**CITY OF PORTLAND, MAINE  
Portland Community Health Center Renovations  
Bid #2713**

Receipt of **Addendum No. 2** to the City of Portland's Bid #2713, **Portland Community Health Center Renovations**: is hereby acknowledged.

**Meeting Minutes****Mandatory Pre-Bid Meeting**

E 100

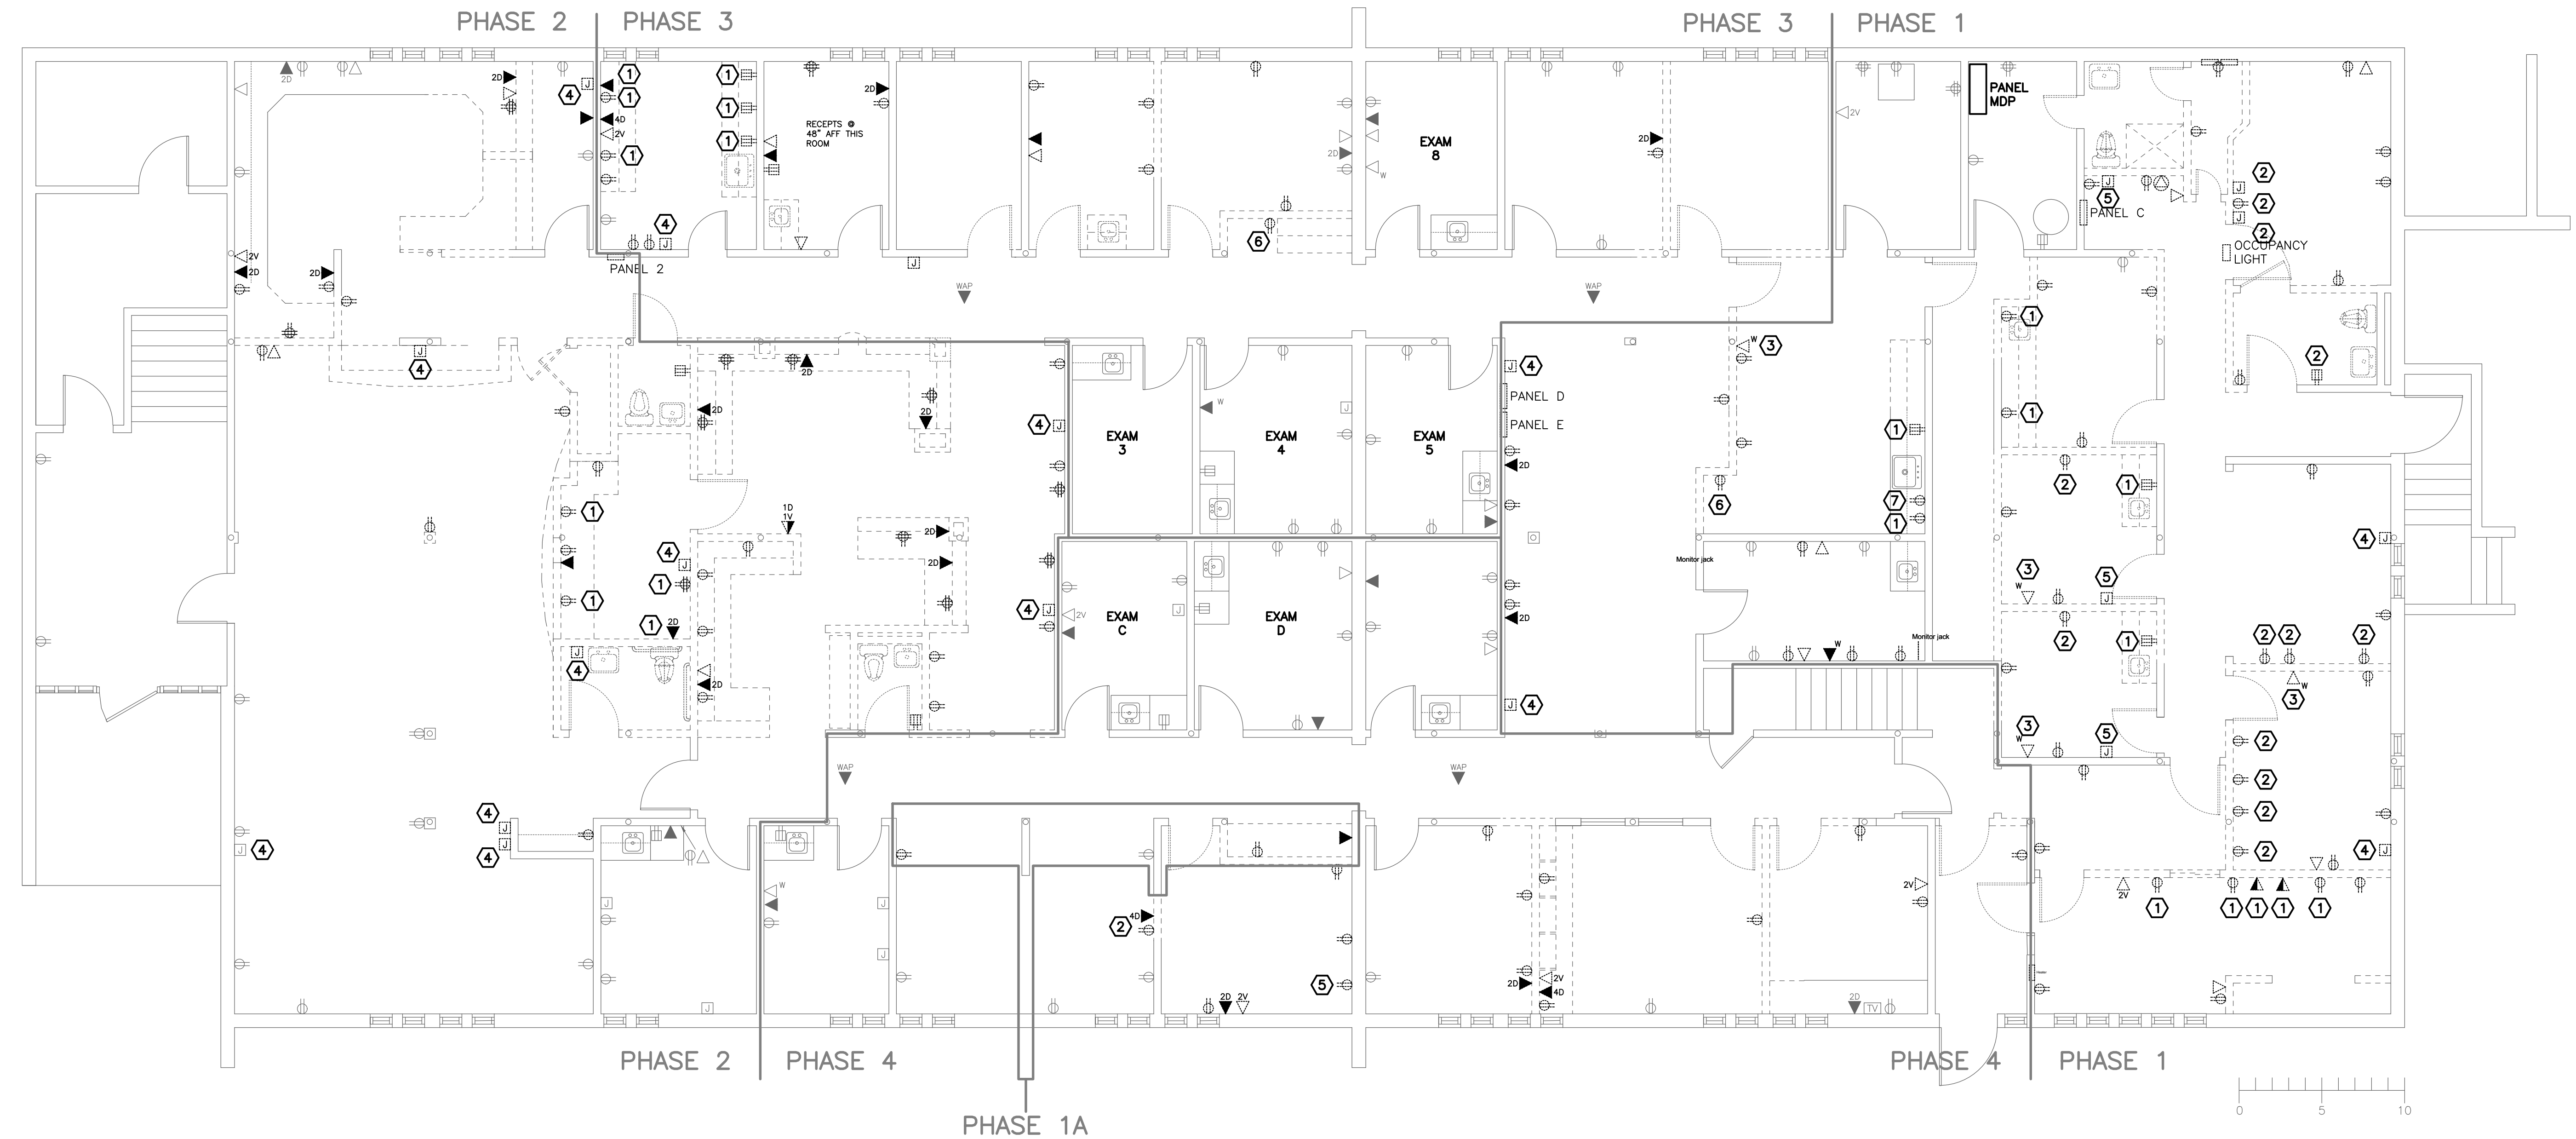
4. *The Electrical Main Disconnect Panel (MDP) is shown on the demolition plan. It is also shown on the Power Plan with a different size. Does the existing MDP remain or is a new MDP to be installed?*

The MDP is existing to remain. See Sheet E102 for MDP Panel Schedule.

E 101

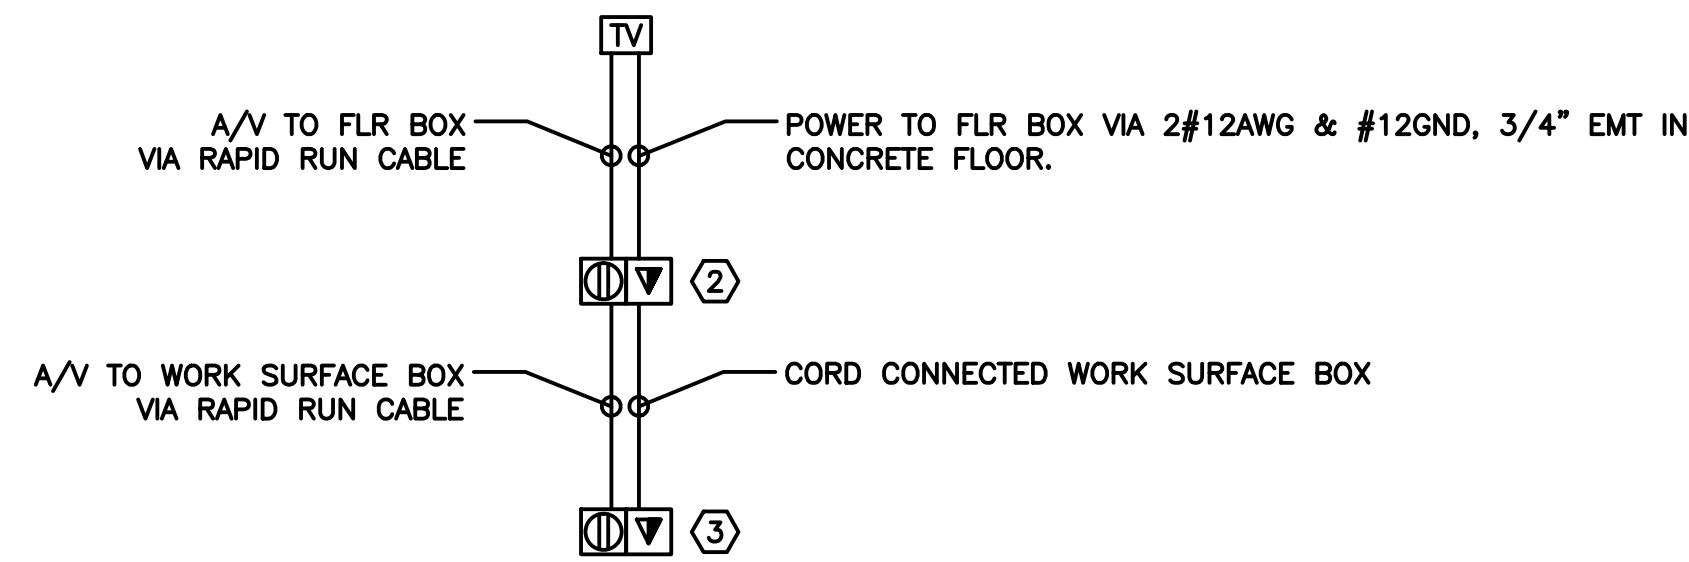
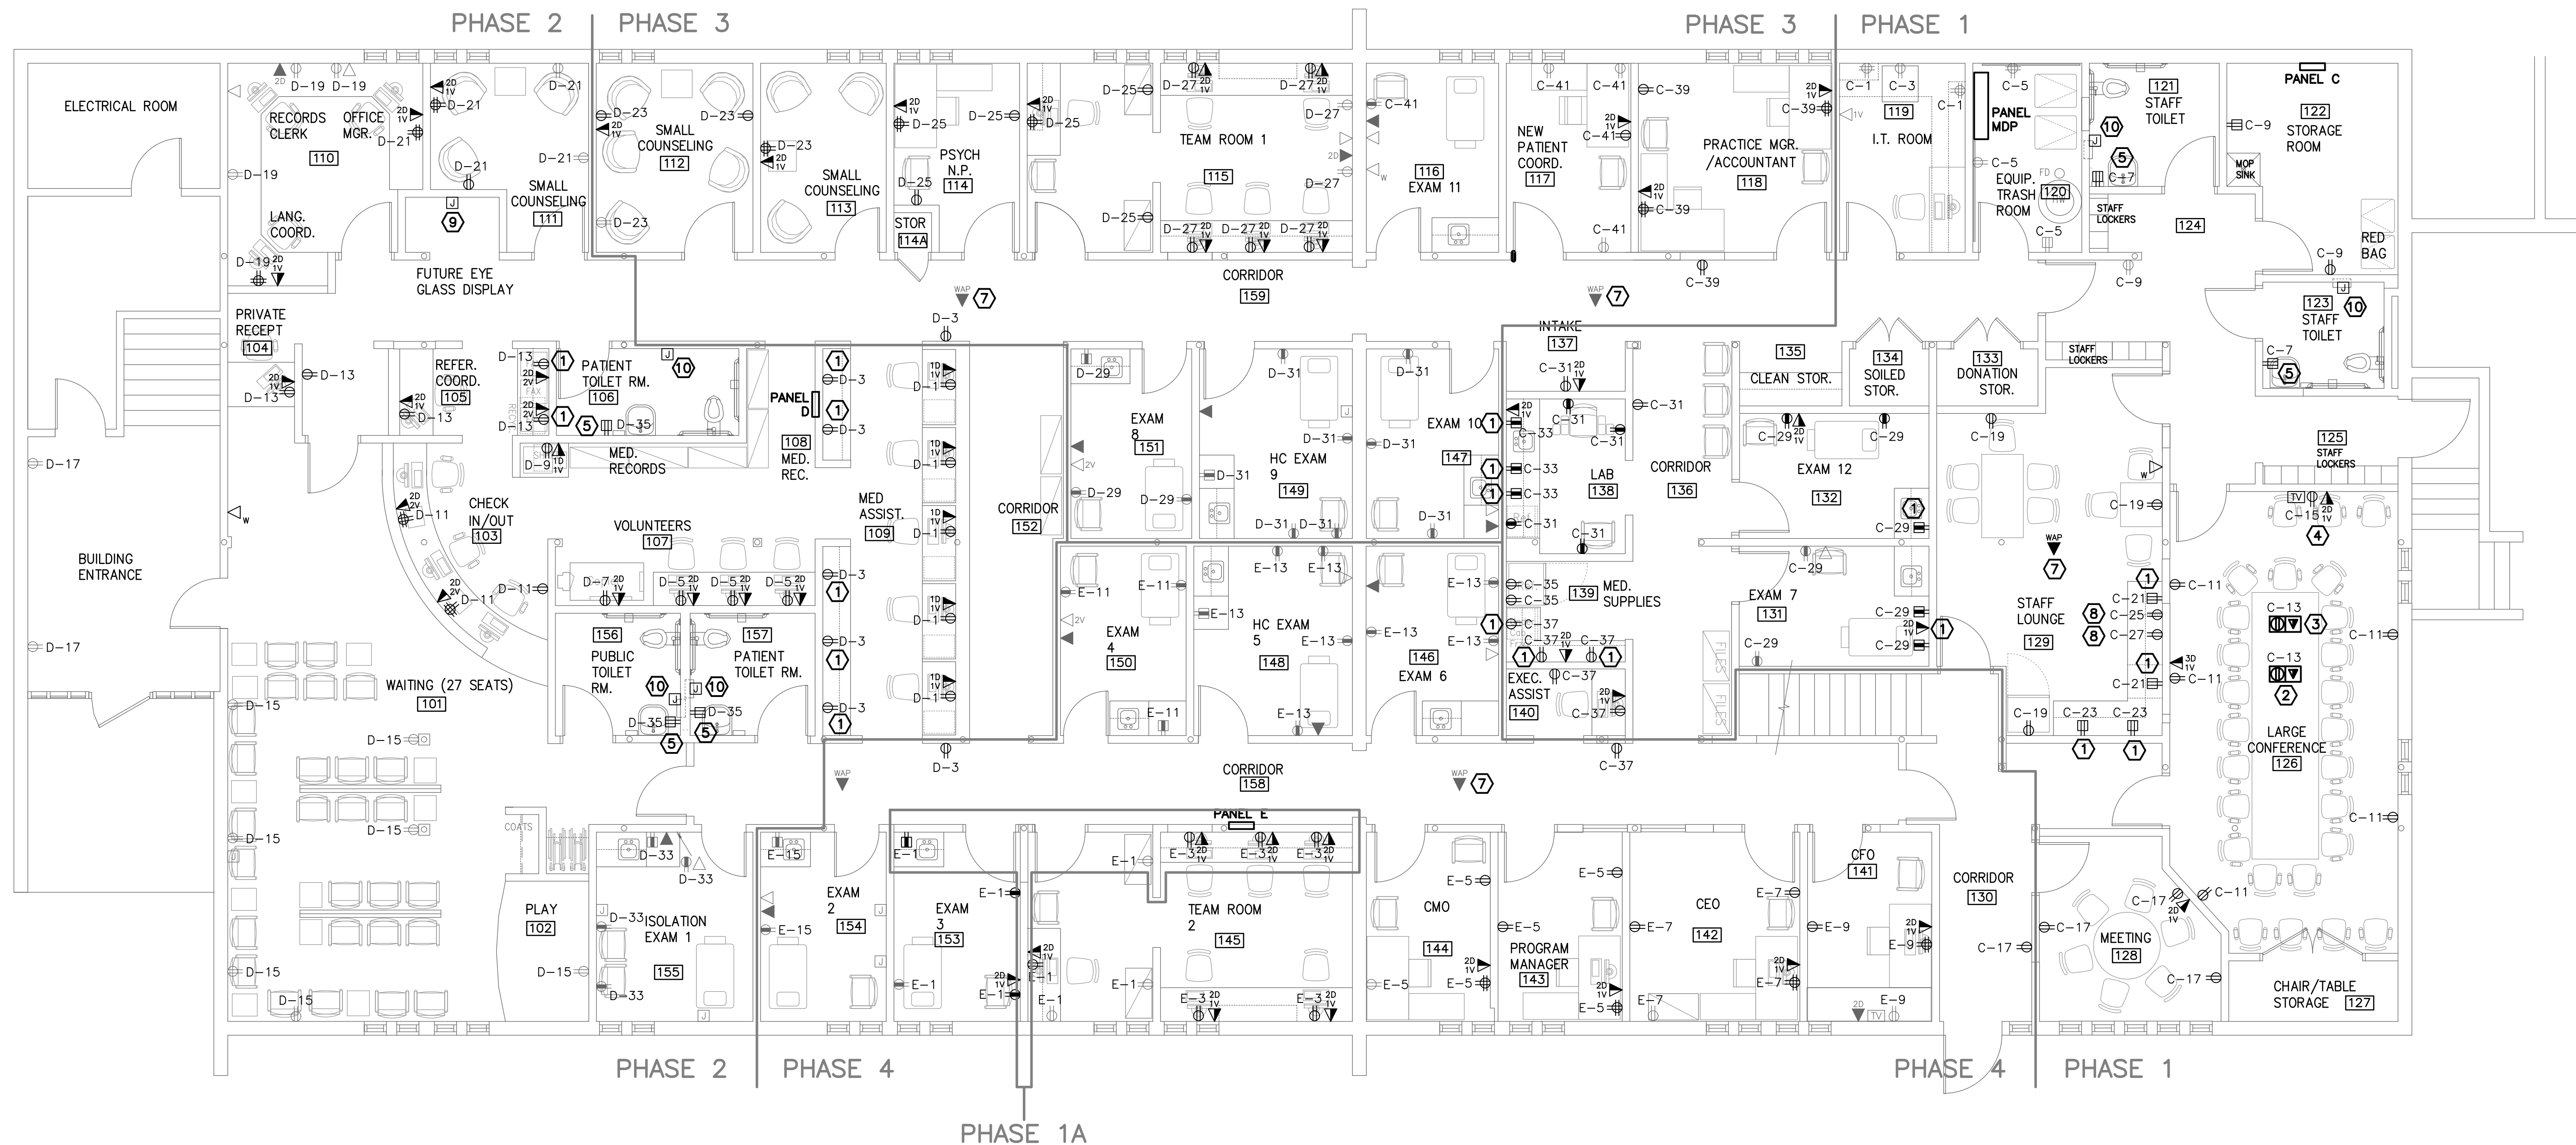
3. *The electrical spec calls out Rapid Run AV cable at the conference room. What specific type of cable is required and what are the required termination types?*

Please reference the attached SKE 101A

Layout Plan

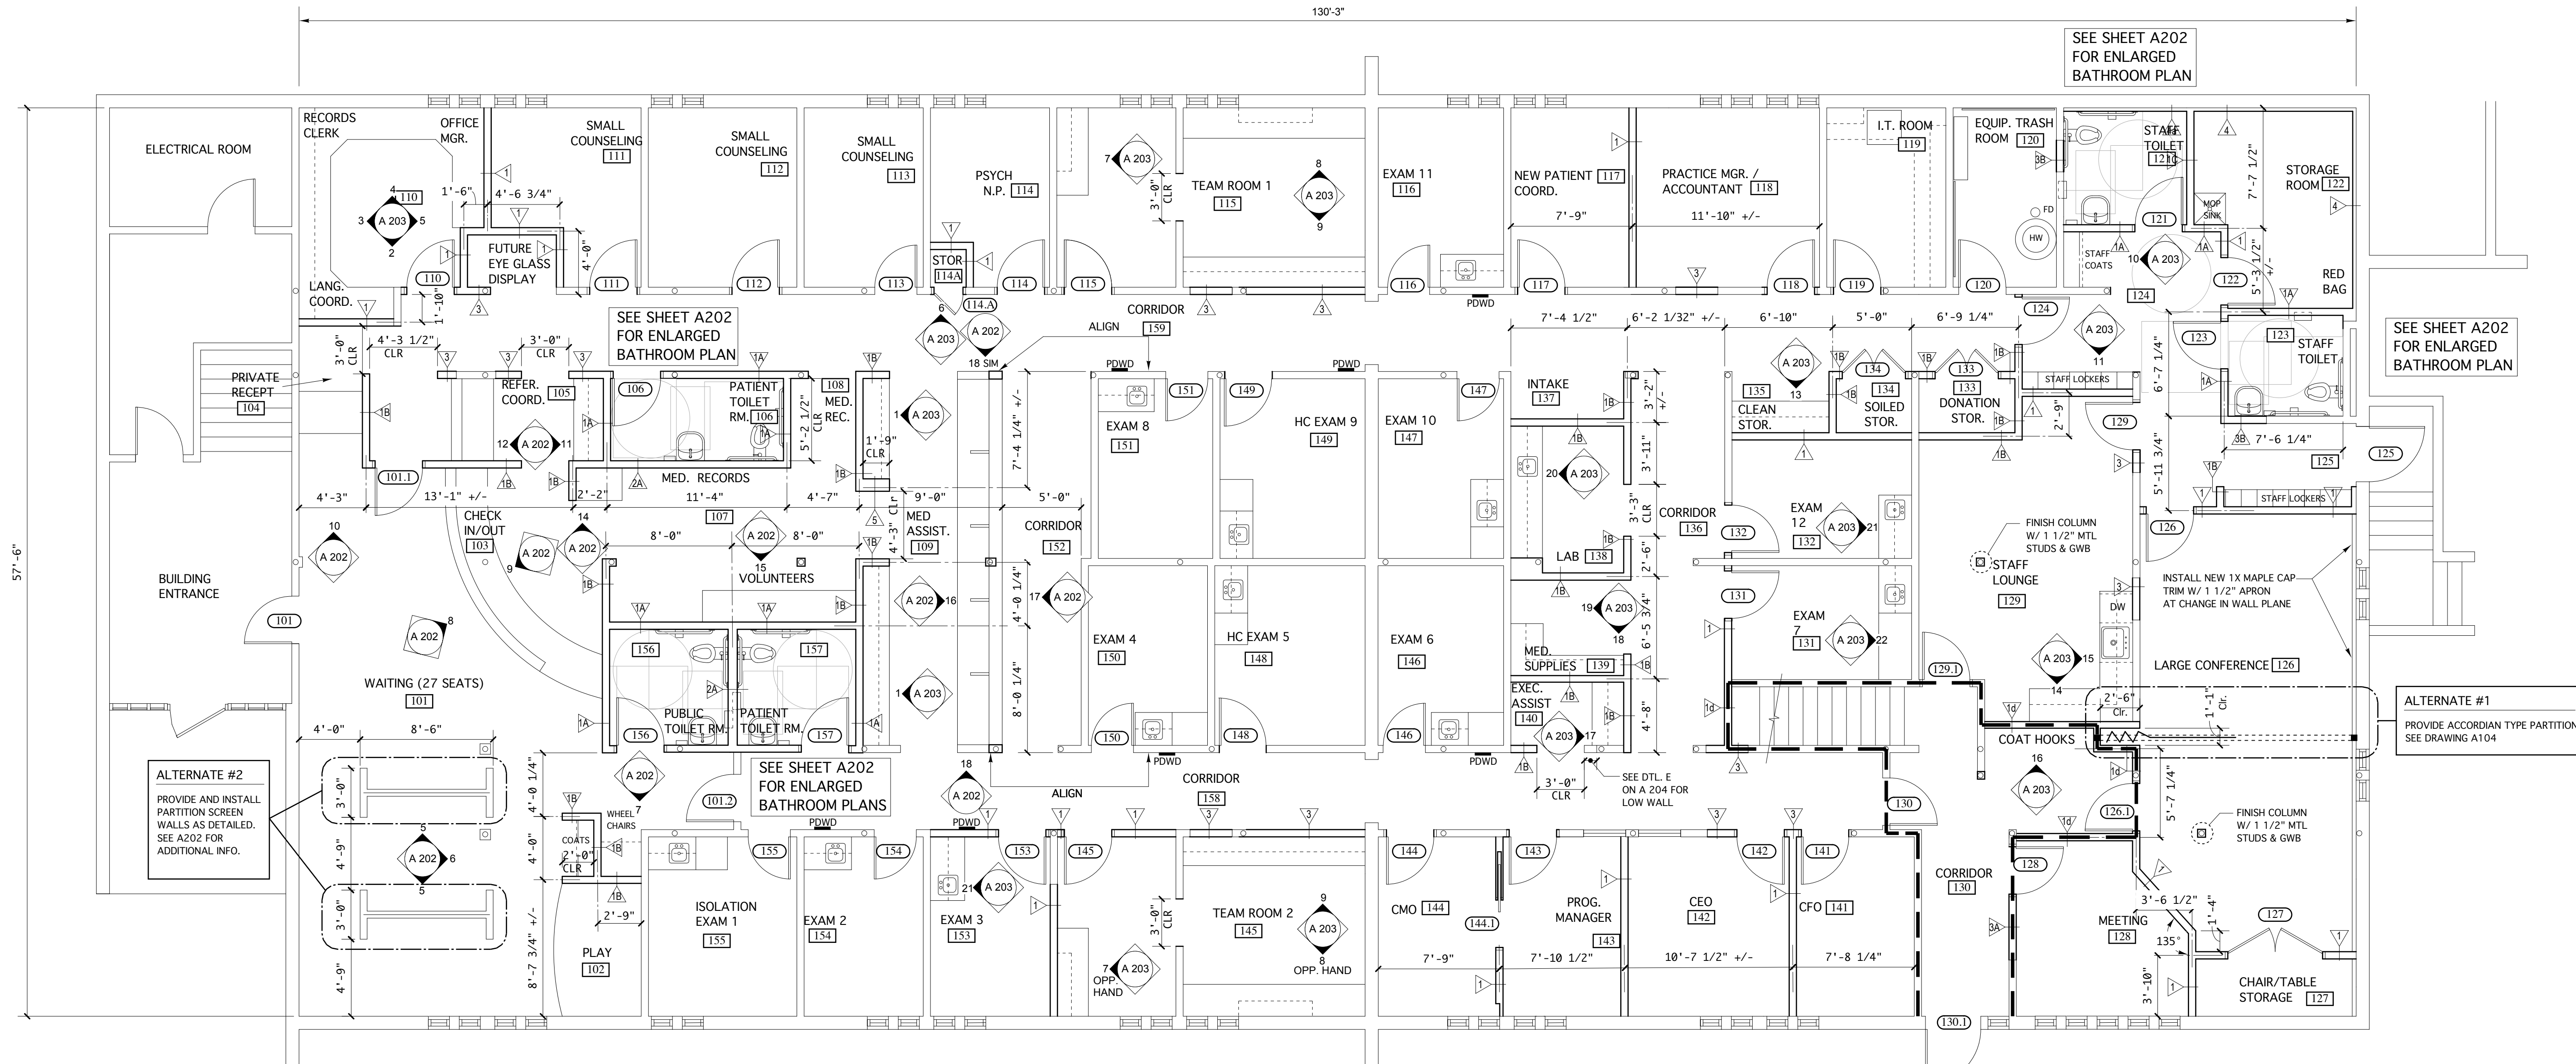
4. *On Drawing A101, IT Room 119 shows dashed lines implying some type of millwork, shelving, counter etc. There does not appear to be any details or elevations for delineating the architect’s intent. Please clarify if this is something to be furnished by the contractor or by the owner.*

The dotted lines were intended to only show on the demolition plan. The lines depict an existing countertop with base cabinets and overhead cabinets to be removed by the contractor.
